6 November 2013

**TNT Warehouse & Distribution Centre (SSD 6040)  
Lot 201 Lockwood Road, Erskine Park**

I refer to the above development application and your letter dated 16 September 2013 inviting comments in relation to the TNT Warehouse and Distribution Centre. Council has examined the proposal, Environmental Impact Statement and other documentation provided and wish to provide the following comments:

A NORTH ELEVATION
200 Scale 1:1000

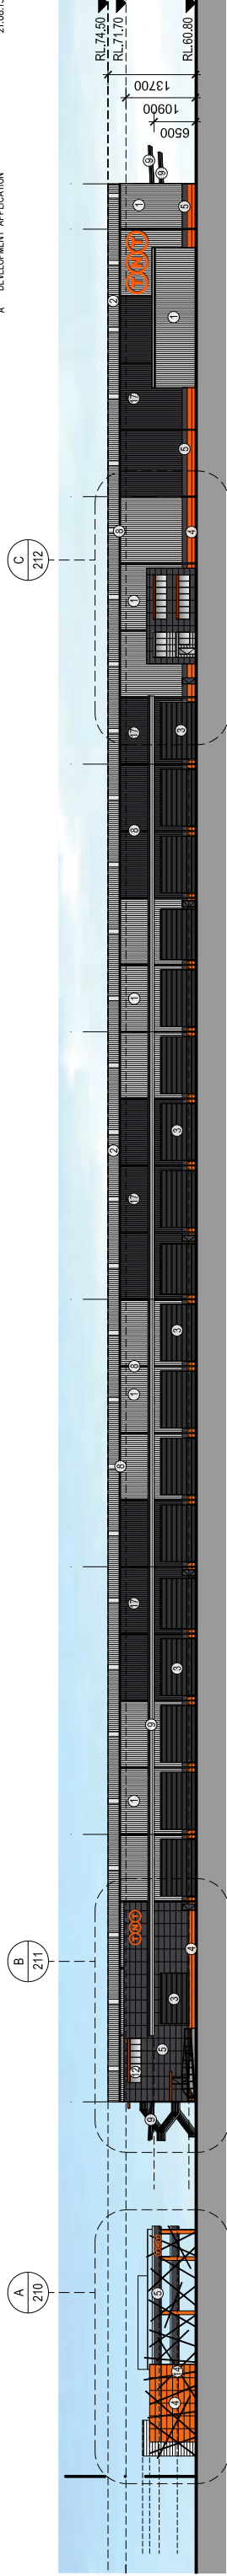
- The northern elevation of the building, orientated to Lenore Drive is considered to be a prominent facade giving its location within Erskine Park and the overall length of the building. It is considered that a number of the following design elements can be included within this elevation:
  - Breaking up the roof from to provide greater articulation within the profile of the building.
  - Greater use of articulation through the punctuation of the wall panels.
  - Greater use of colour. The orange band within the building is noted, however its location will be screened by vehicles and landscaping. The alternating panels are not considered to enough to provide visual interest.
  - The use of exposed frames and oversized elements such as downpipes to create visual interest

Note: these comments do not relate to the car park area facing Lenore Drive.
- The depth of the awning on the northern elevation of the building is not considered to be an appropriate depth to provide all weather protection of vehicles being loaded & unloaded outside of the building.
- Consideration should be given to the provision of a sleep quarters/ washing facilities within the building, particularly for interstate drivers attending the site.
